Rezoning Transportation Analysis

Petition Number: #2023-018

Revision Log:

| Date | Description |
|----------|-------------------|
| 06-22-23 | First Review (TM) |

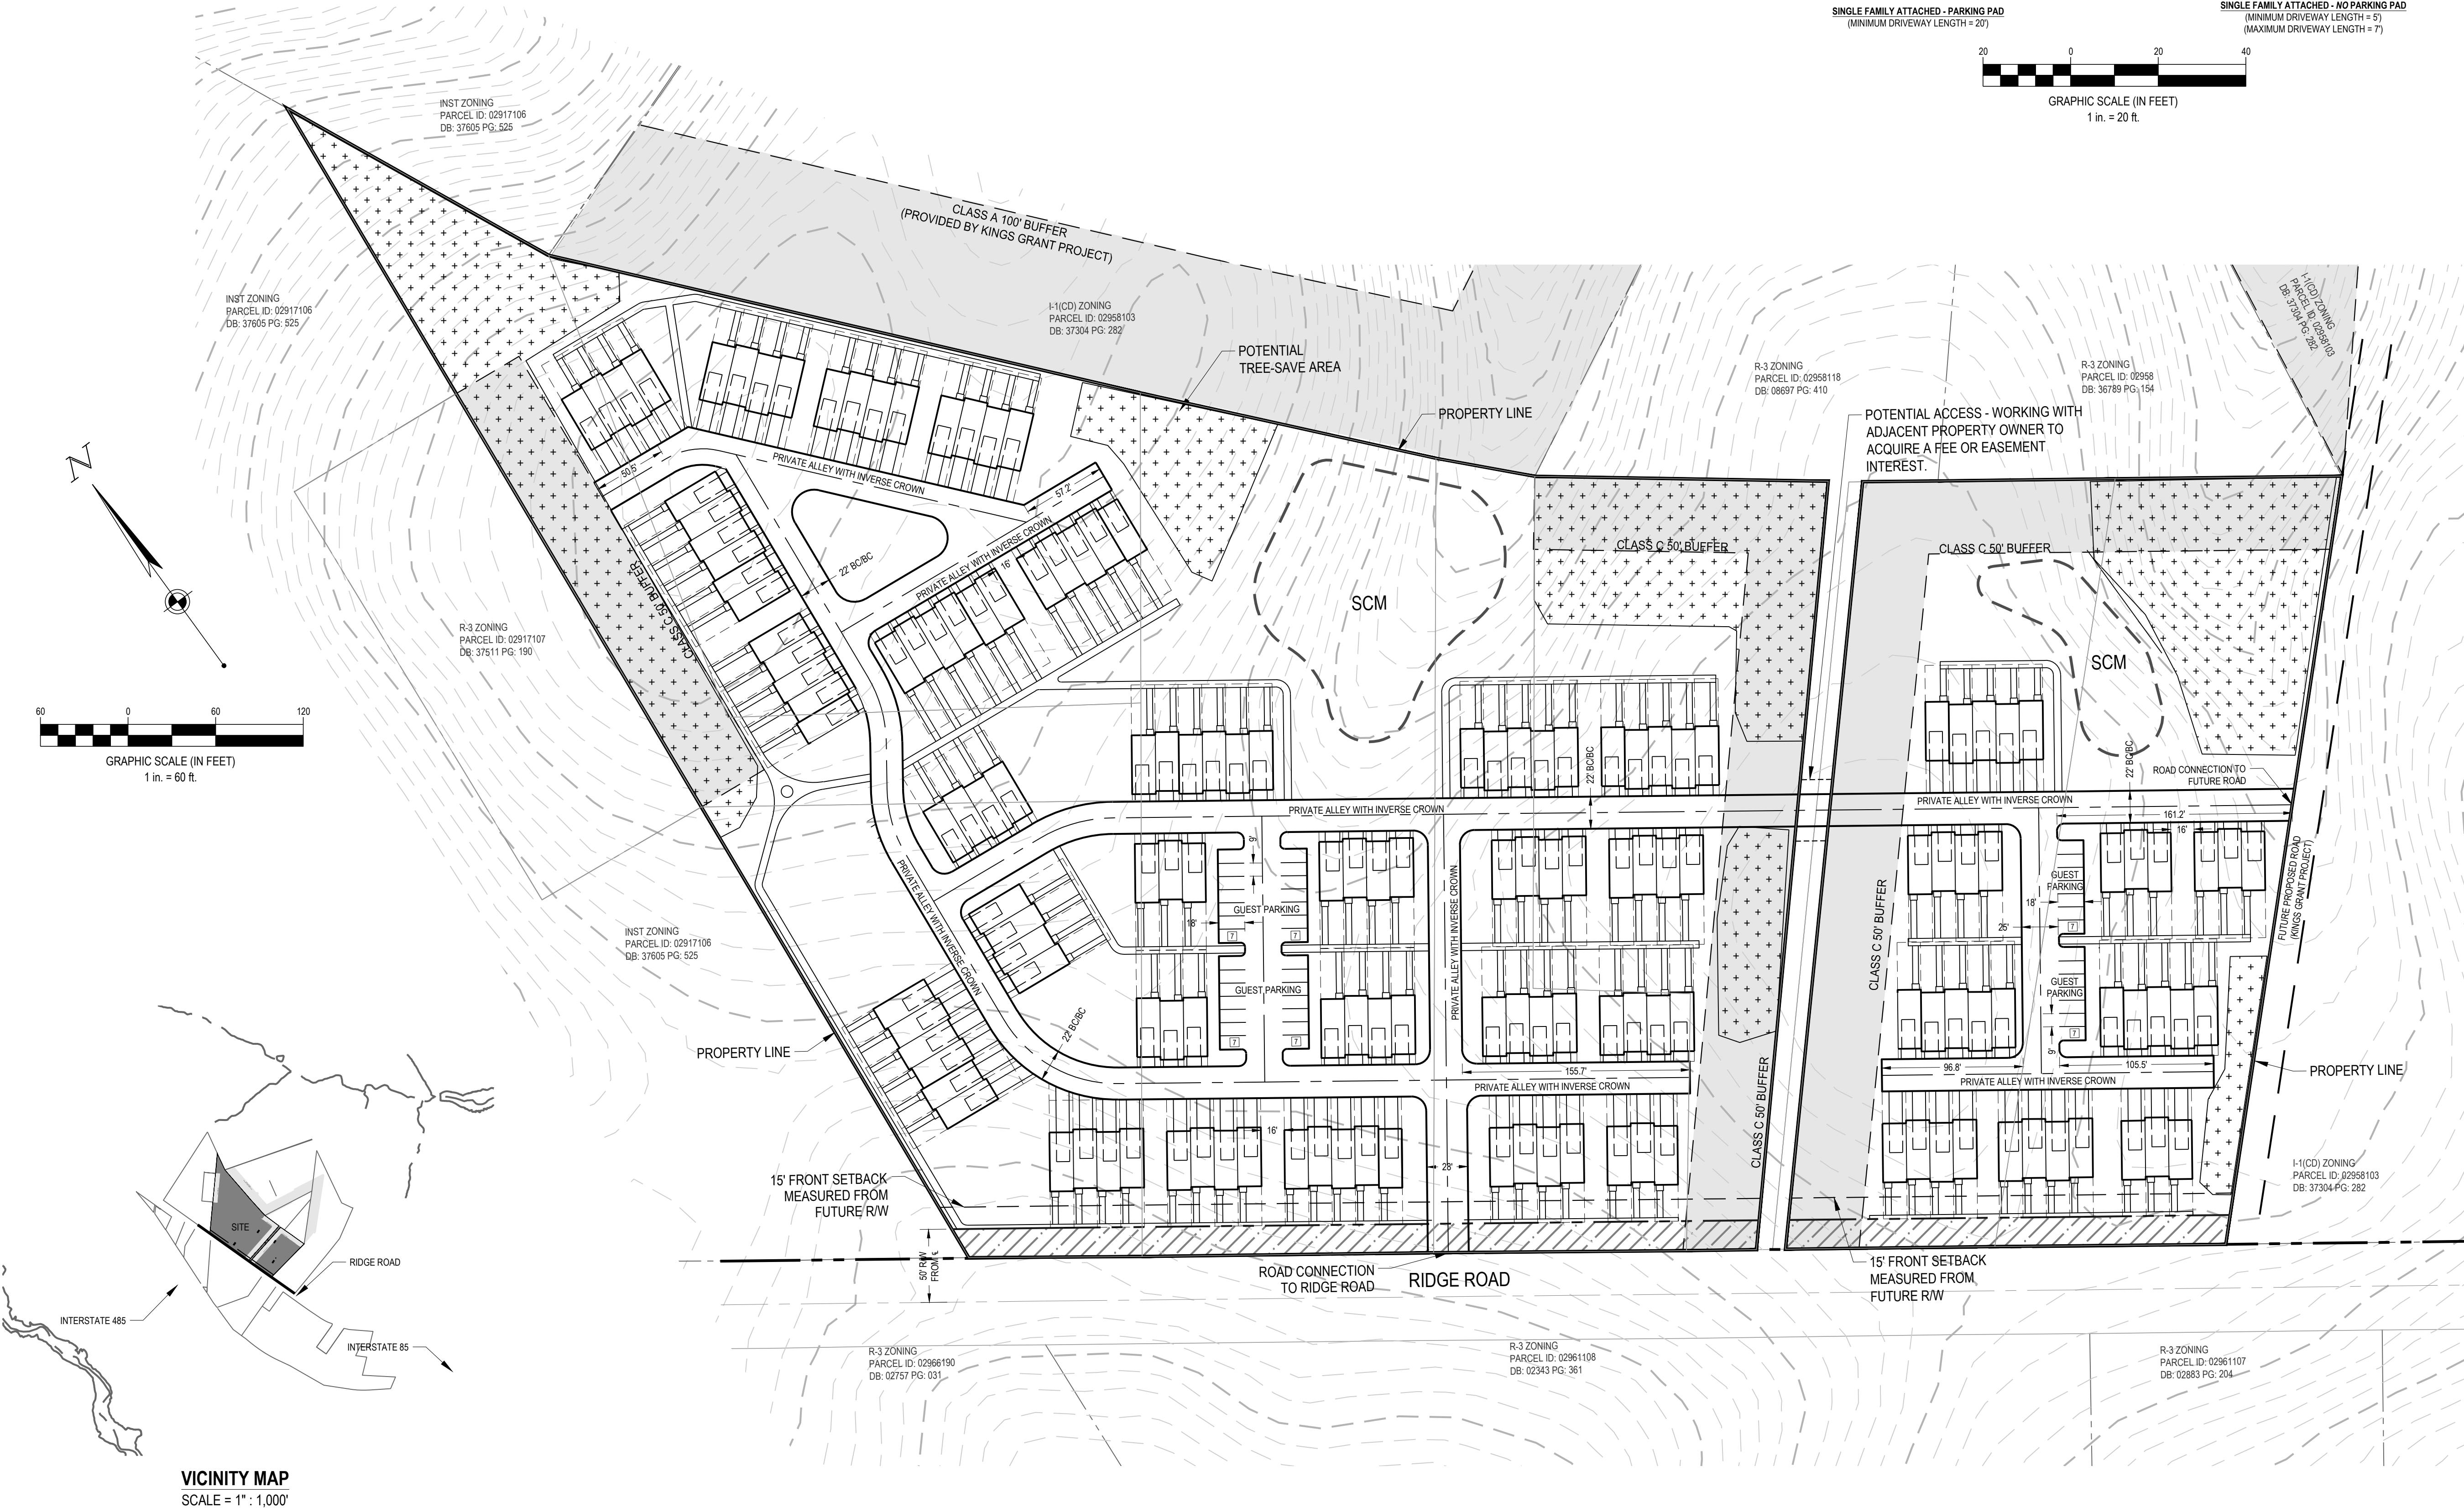
- a. **Ridge Road:** Location of curb and gutter to be 30-feet feet from roadway centerline to accommodate the Charlotte Streets Map with a roadway typical section of a 4+ Avenue, Shared Use Path.

Label and dimension the curb and gutter from the centerline for each road on the site plan.

3. Revise site plan and conditional note(s) to commit to construct bicycle facilities by installing a 12' multi-use path to meet the Council-adopted Charlotte BIKES Policy. Multi-use paths maintained by the City shall meet ADA/PROWAG requirements.

5. Revise site plan and conditional note(s) to commit to widening Ridge Road to accommodate a two way left turn lane and dedicated right-turn lane at the sites frontage in coordination with NCDOT.

6. Revise site plan and conditional note(s) to commit to coordinating internal roadway network with Kings Grant rezoning 2023-024.
7. Revise site plan and conditional note(s) to commit to coordinating with NCDOT regarding site access location in coordination Kings Grant rezoning 2023-024.

8. Revise site plan and conditional note(s) to commit to coordinating with Subdivision regarding internal street network requirements as the site does not meet Subdivision requirements.

12. Revise site plan and conditional note(s) to construct 8-foot planting strips and 12-foot multi-use paths on Ridge Road. The site plan shall label and dimension both items from the back of curb and gutter or edge of pavement. Add conditional note The entire facility must be outside of the right of way and within a public access easement. Add conditional note committing to construction and maintenance of the 12-foot multi-use paths on Ridge Road.
